File no: SSD 9368; MC-19-00004.

**Re: SSD9368 - Farmland Drive SCHOFIELDS – Modification Application for
Alex Avenue Public School Mod 3 - Staging**

ATTACHMENT A

Figure 5 | Amended staging plan (Source: Applicant's Modification Application 2020)

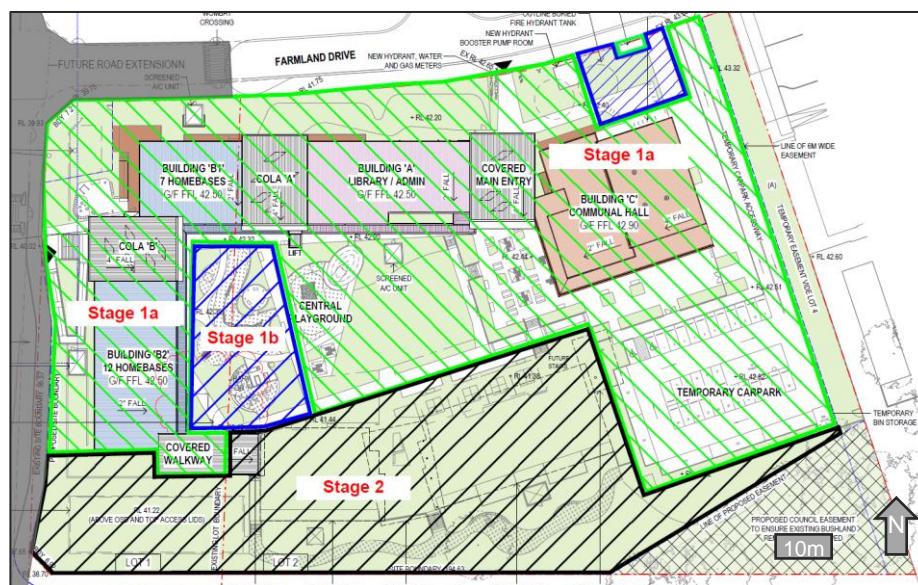
1. There is no mention of the basketball/multi-purpose courts in the staging plan. When they will be constructed?
2. We cannot deliver the cricket nets at R885 until Easement A is extinguished as levels will be required to be resolved between the 2 sites in this location.
3. Clarification is sought as to what the notation "Proposed Council Easement to ensure existing bushland remains undeveloped" on the SE corner of the site which is hatched means.

5. We strongly disagree with the proposed staging plan as presented. To ensure no adverse impact, the on-site stormwater detention tank including water quality and the separate rainwater tank must be completed in Stage 1.

Figure 7 | Proposed management arrangements (Source: Applicant's Modification Application 2020)

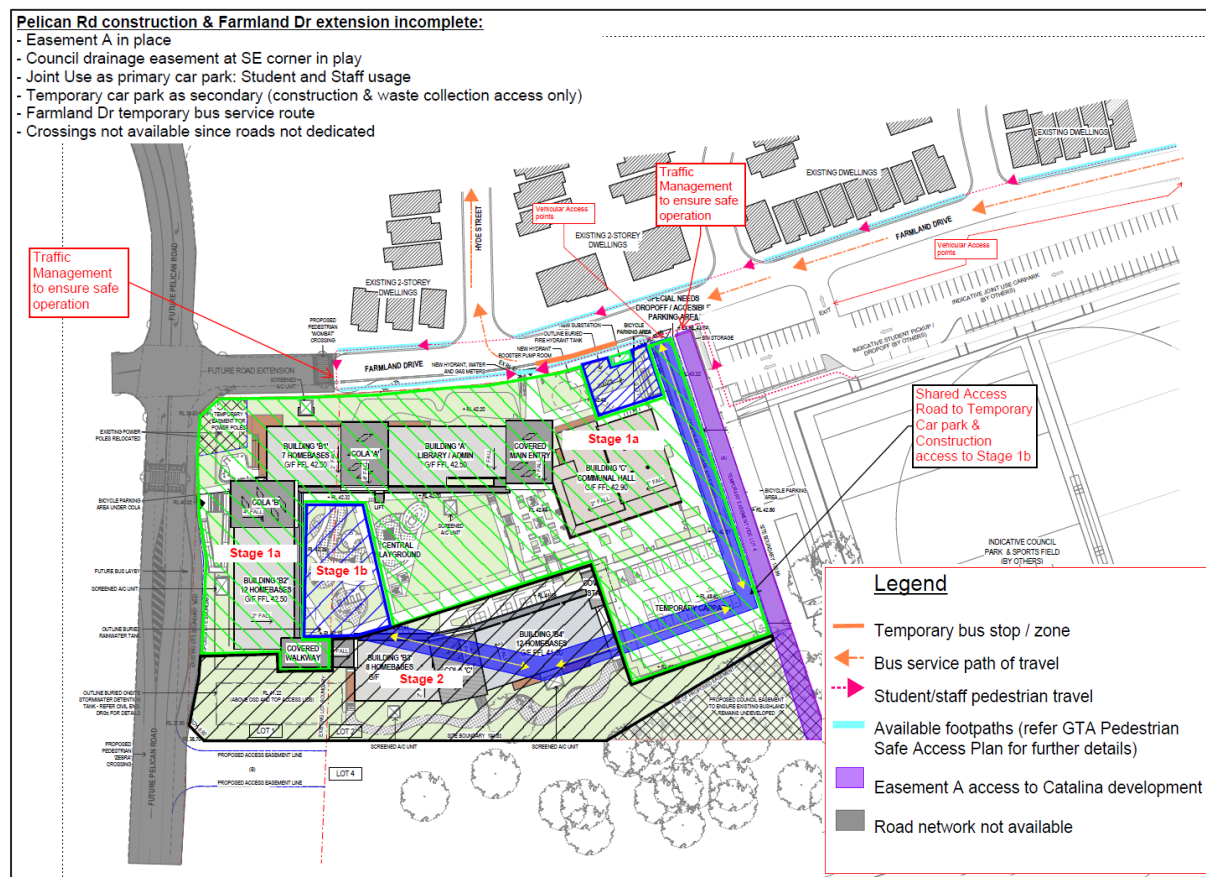
7. Access to Easement A must not affect any existing trees required to be retained for this development. This includes the proposed Council easement (bushland remains undeveloped easement) at the south end of Easement A.
8. Any impacts on trees to be retained near Easement A must be reported to Council in the form of an Arboricultural Impact Assessment (AIA). The AIA must provide
